CITY OF ALBUQUERQUE

Re: Zia Napa Auto Care
5312 Phoenix Ave NE, 87110
30-Day Temporary Certificate of Occupancy
Transportation Development Final Inspection
Engineer's/Architect's Stamp dated 12-11-19 (H18D056)
Certification dated 6-17-20

TRAFFIC CERTIFICATION

SITE PLAN / TRAFFIC CIRCULATION LAYOUT

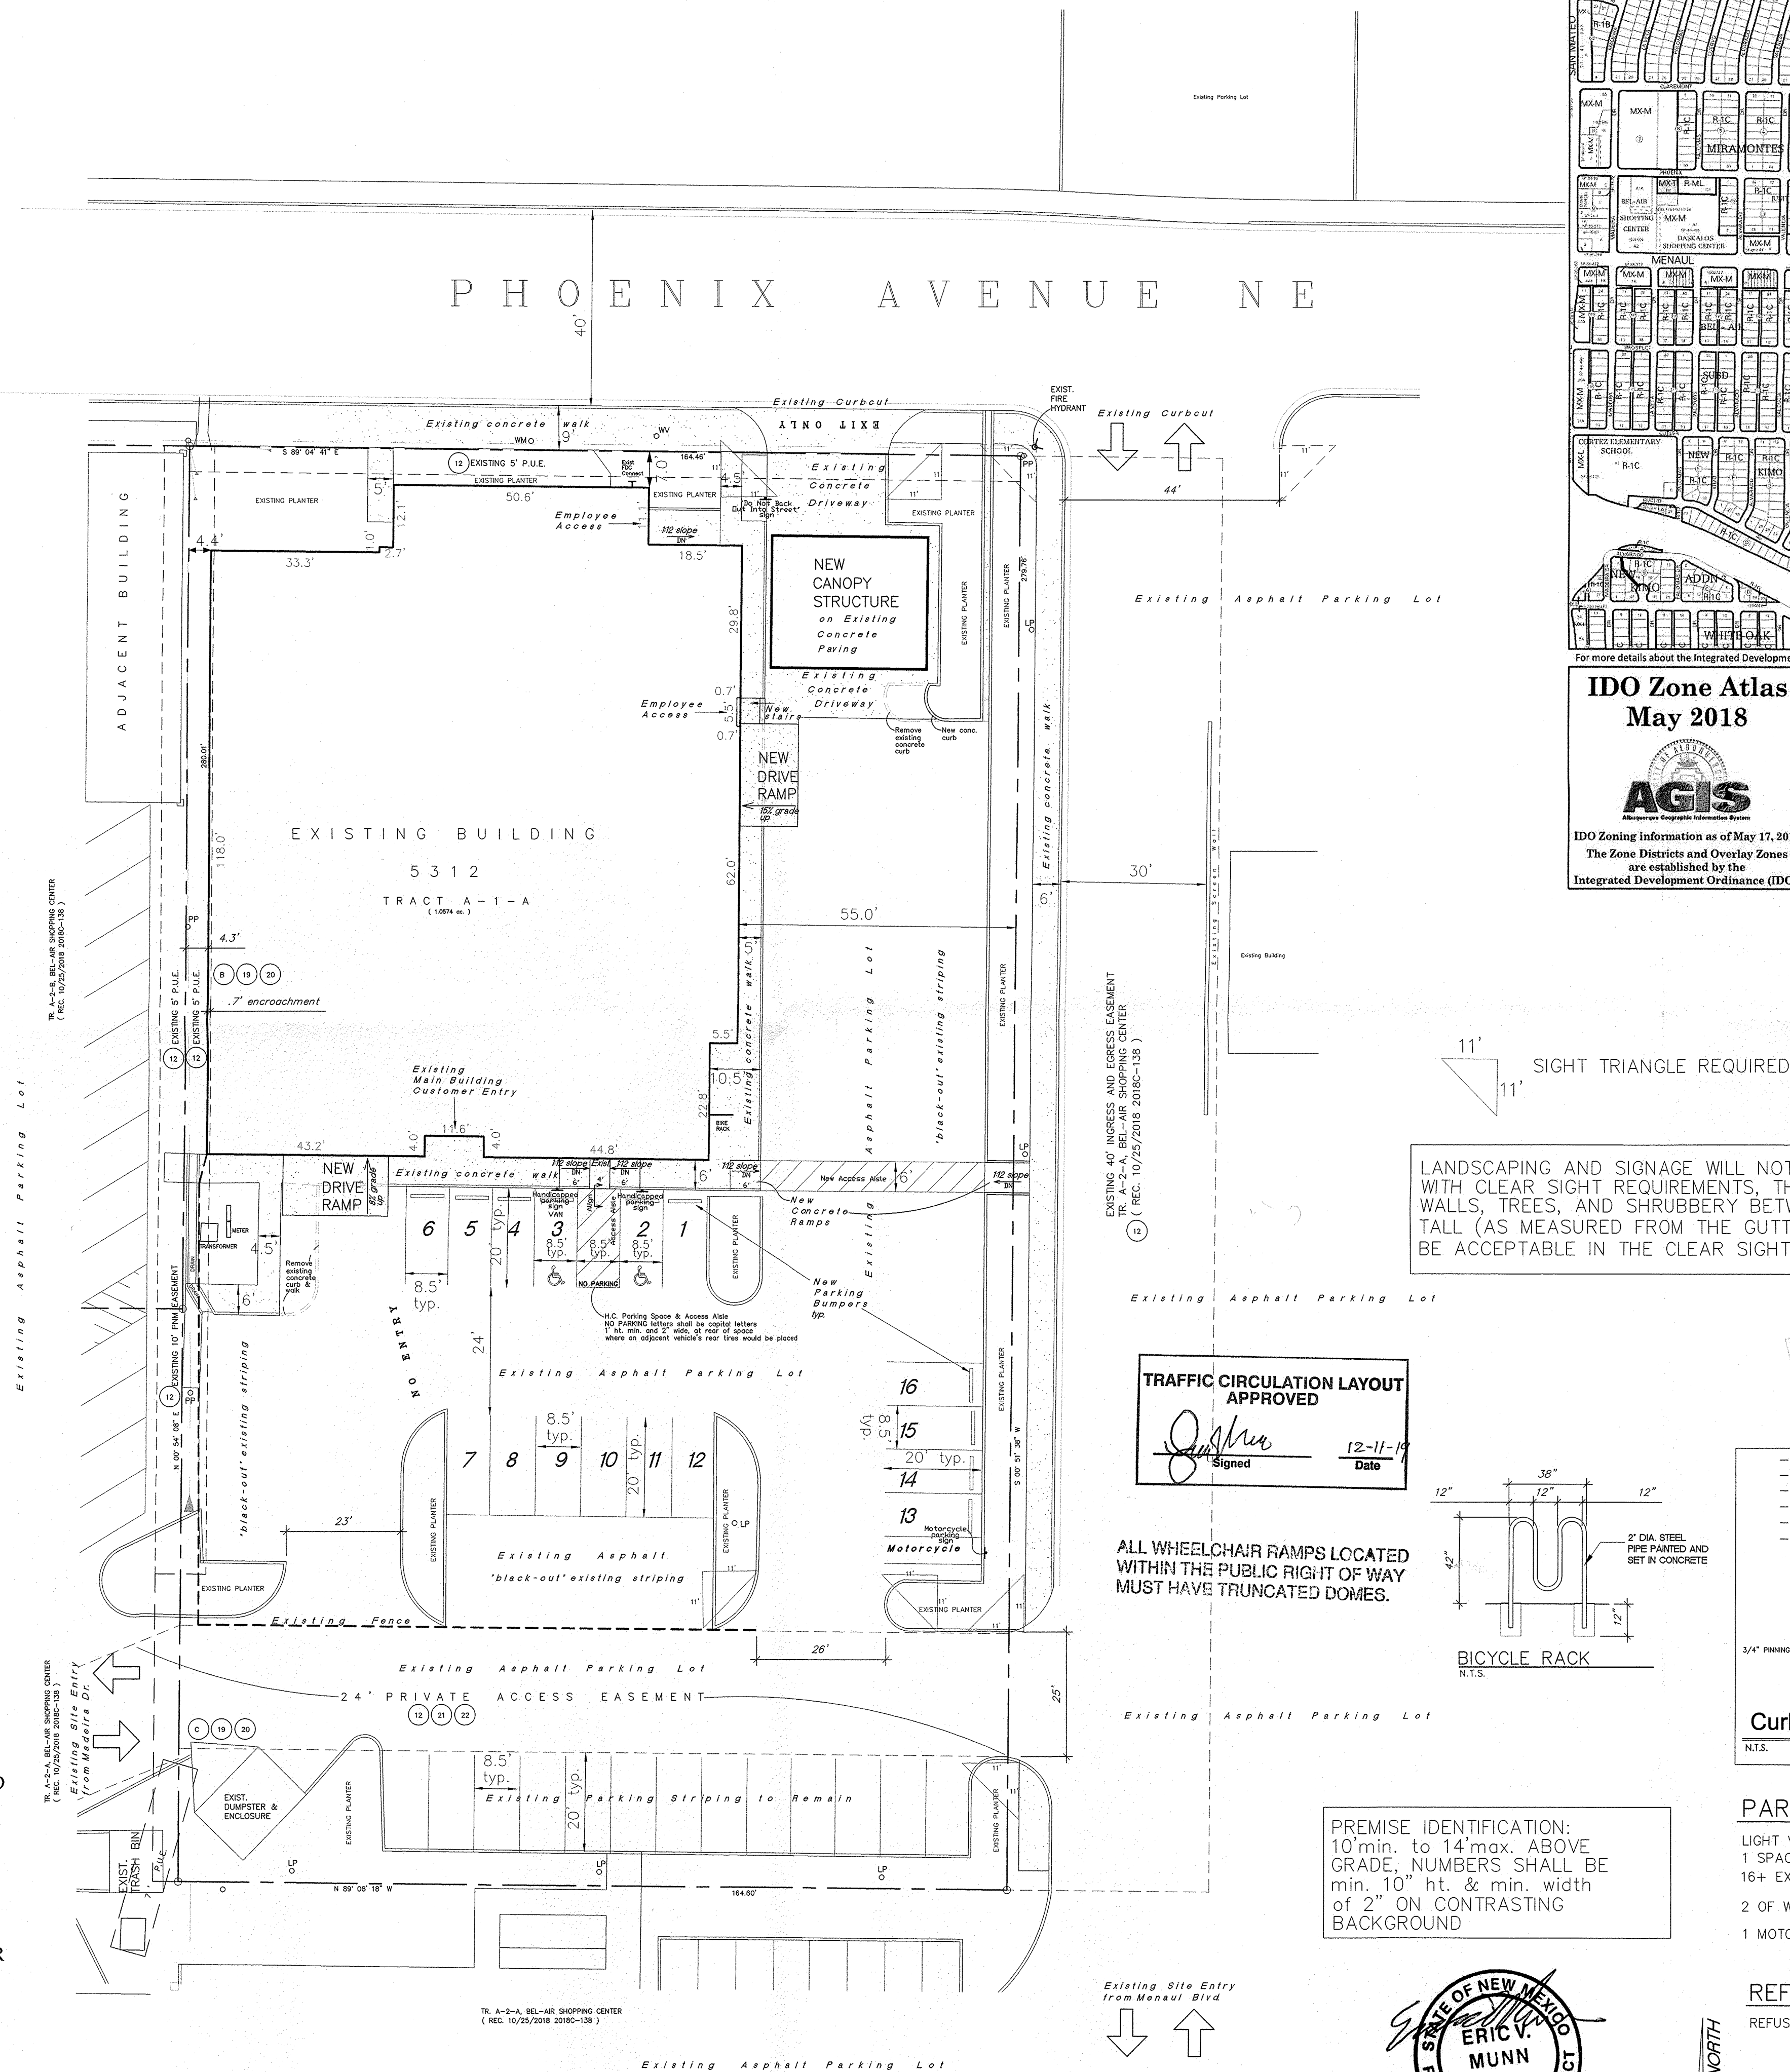
- Please add Truncated Domes to Wheelchair ramps located in the public right of way.
- Please remove temporary security fence, porta potty & construction debris.
